Please ask for: Ms Iqraa Malik  
Email: [iqraa.malik@terraquest.co.uk](mailto:iqraa.malik@terraquest.co.uk)  
Telephone: 01212341390  
Our Ref: FP/175/20/HH  
Your Ref:  
Date: 23rd September 2020

**Application for Planning Permission for Works or Extension to a Dwelling**

**Development:** Single storey side extension.  
Two-storey rear extension.  
Internal alterations  
**Location:** 23 Thirlmere Way Felpham PO22 8NQ

Drawing Title:
PROPOSED PLANS AND ELEVATIONS

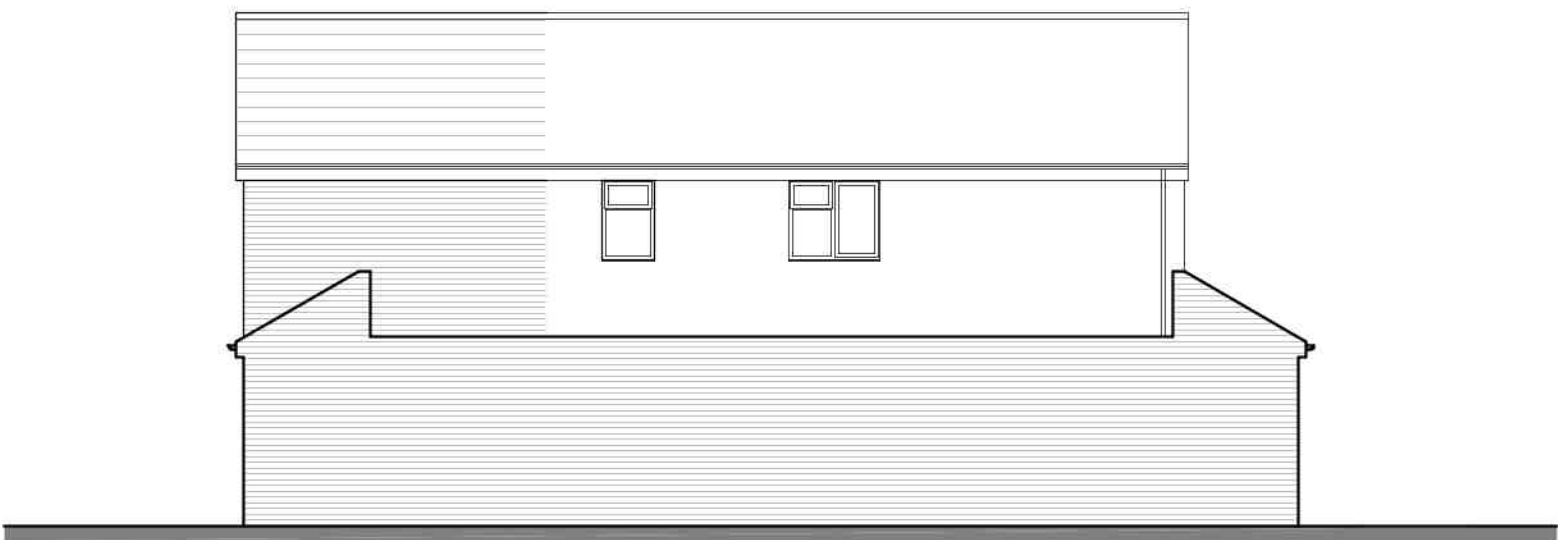
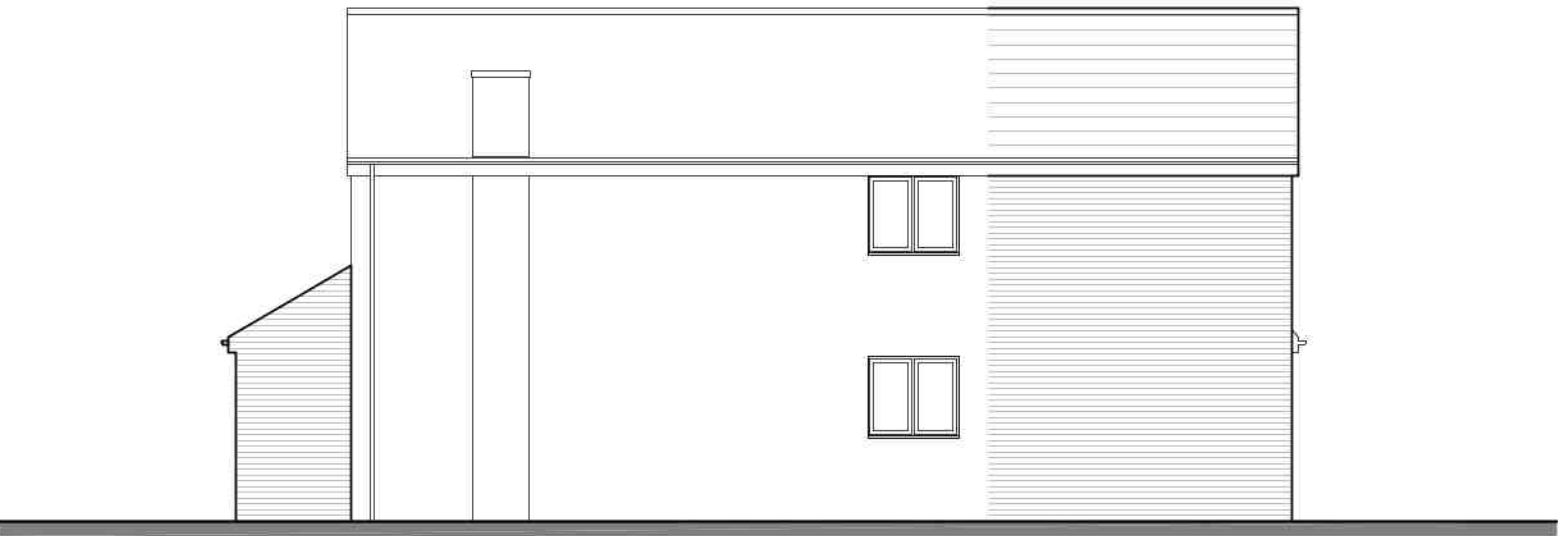
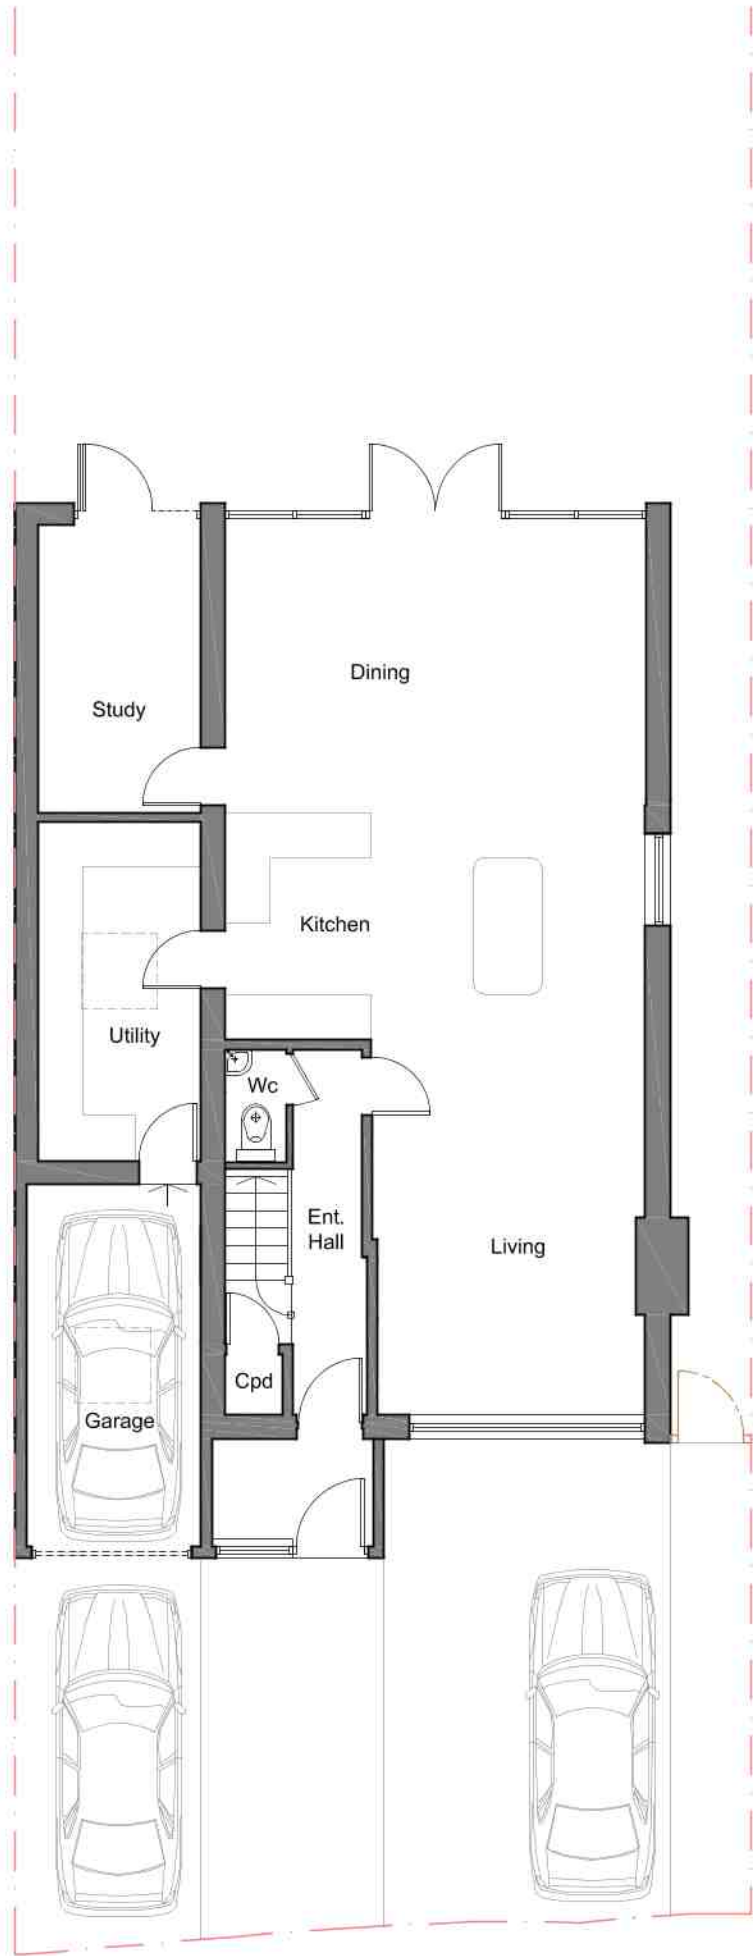
The window shown on the side of the ground floor plan is missing from the side elevation. Please amend.
